**WEST SUSSEX COUNTY COUNCIL
INFRASTRUCTURE CONSULTATION**

SUBJECT: WA/39/10-Outline Application with some matters reserved for redevelopment to provide four new houses.

Deans Yard, Orchard Way, Fontwell, West Sussex

**Proposed Development**  
**Block & Site Plan.**

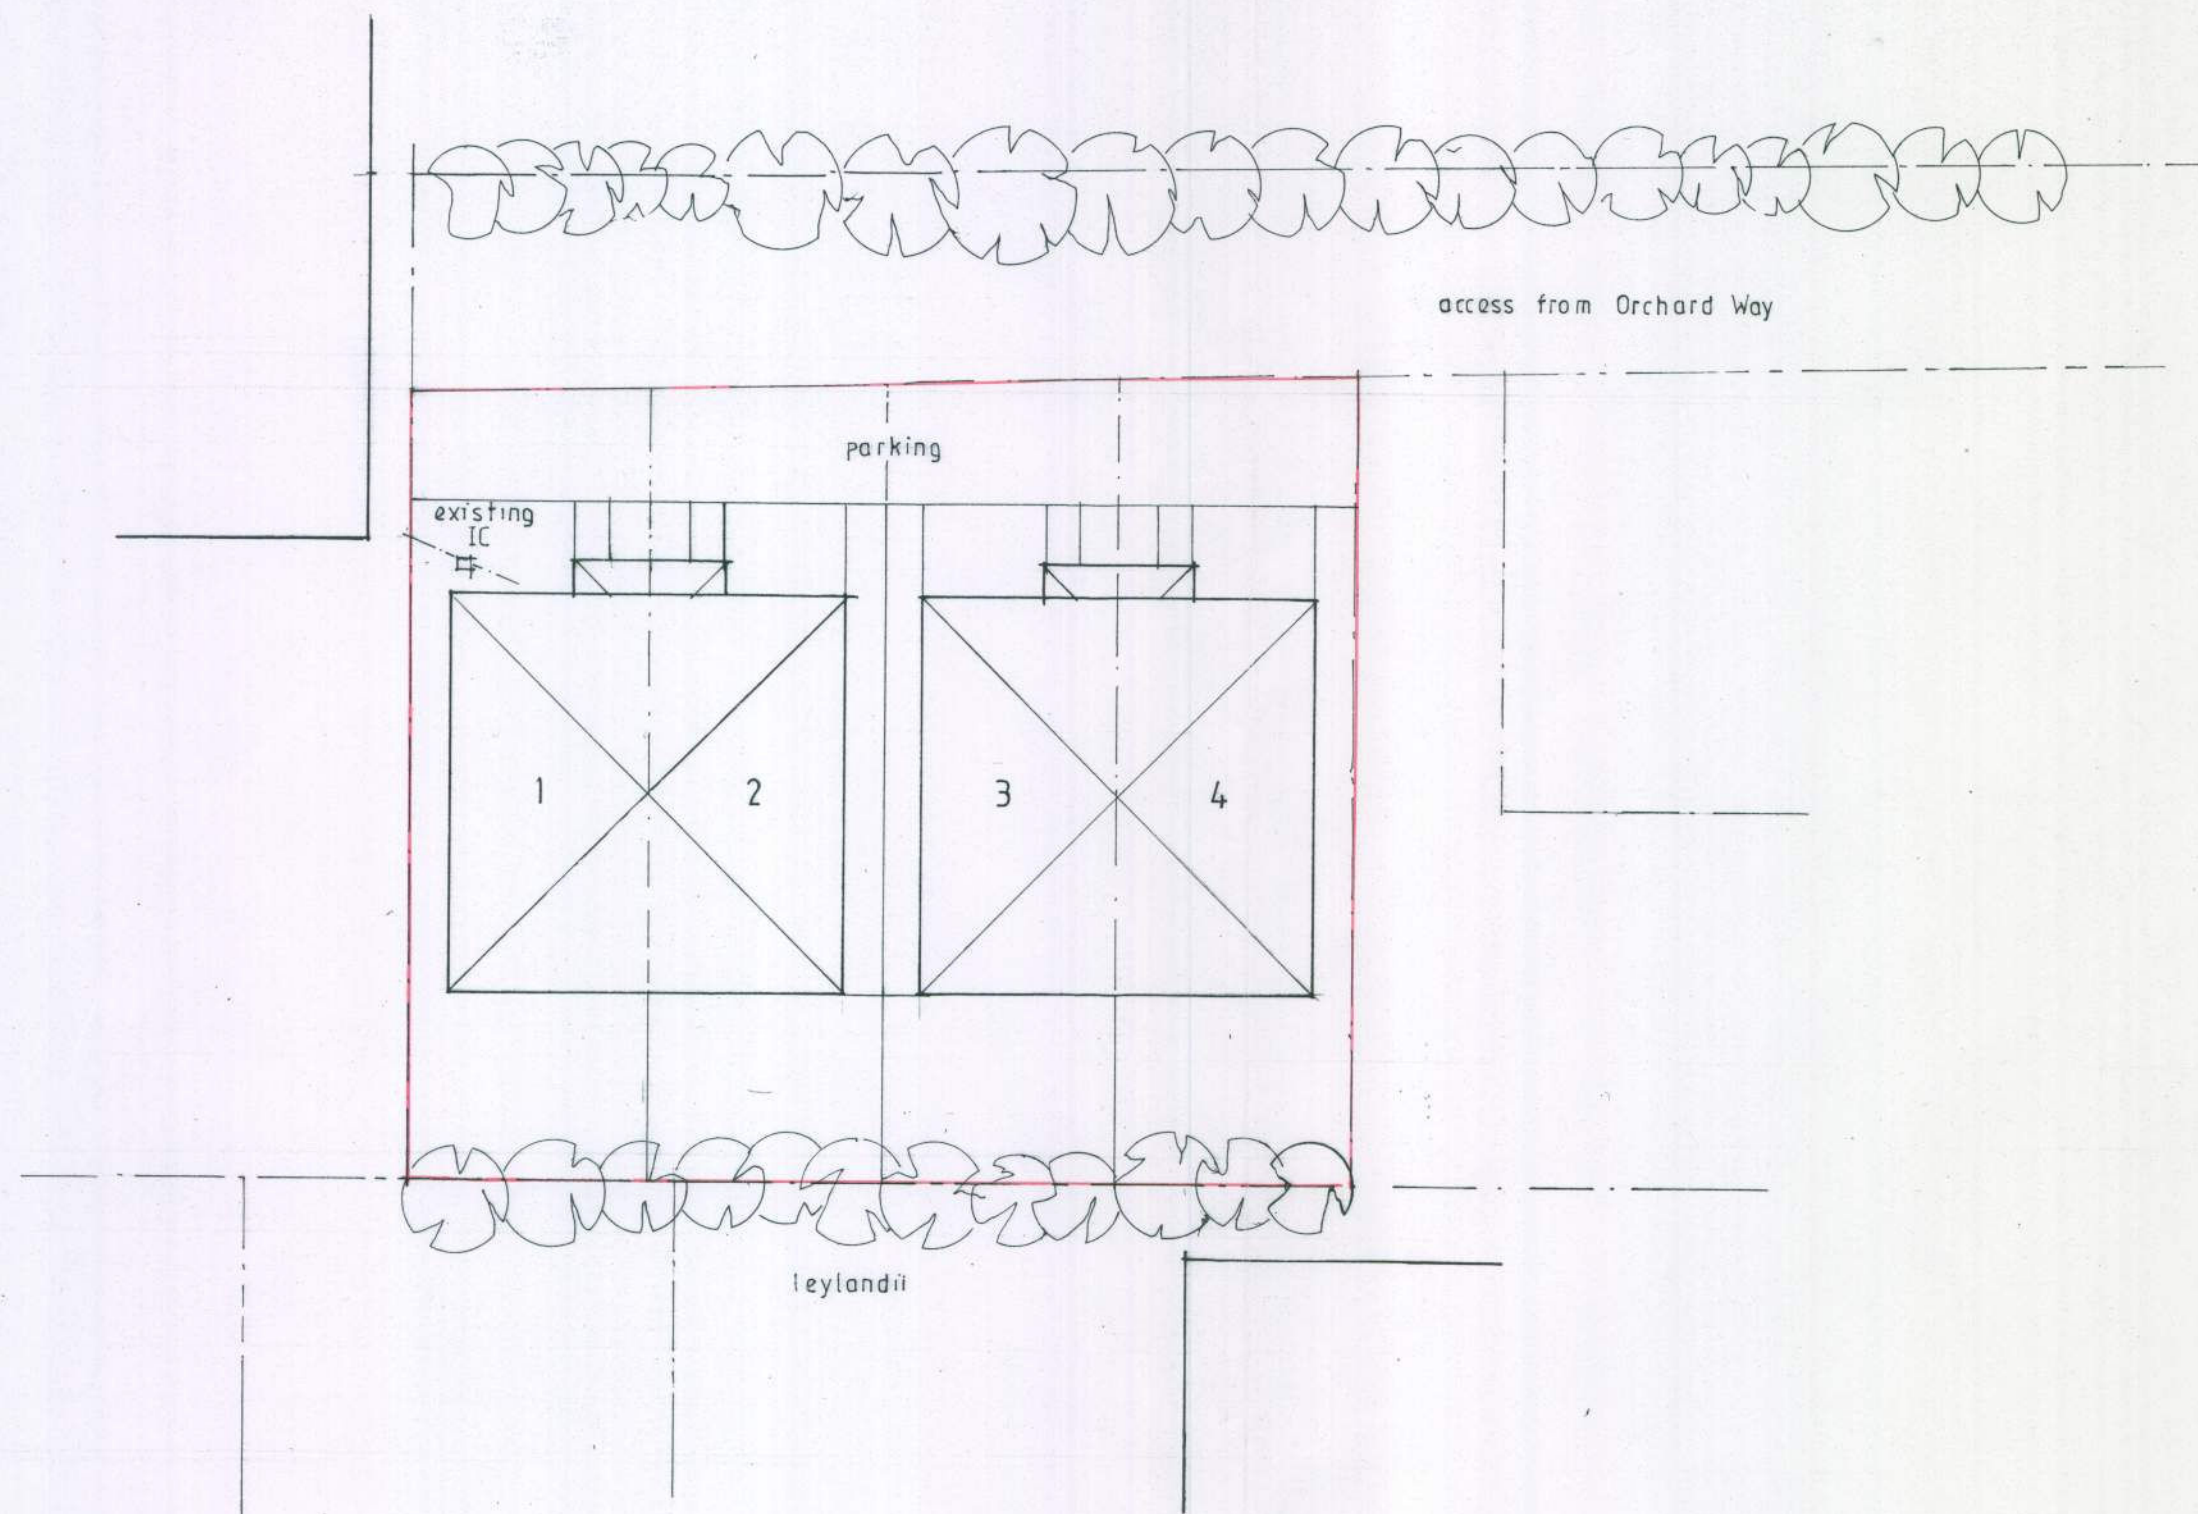
The proposal will utilise the existing access and estate road onto Orchard Way. The access is approximately 5.2 metres in width currently. In terms of parking I can confirm that the proposed level of parking does not exceed the WSCC maximum parking standard. In terms of parking layout, turning should be achievable within the opening of the access road. I would also recommend that cycle parking in line with the WSCC minimum standards is also secured via condition; this must be secure and covered.

If the LPA are minded to approve this application a condition securing cycle parking should be included.
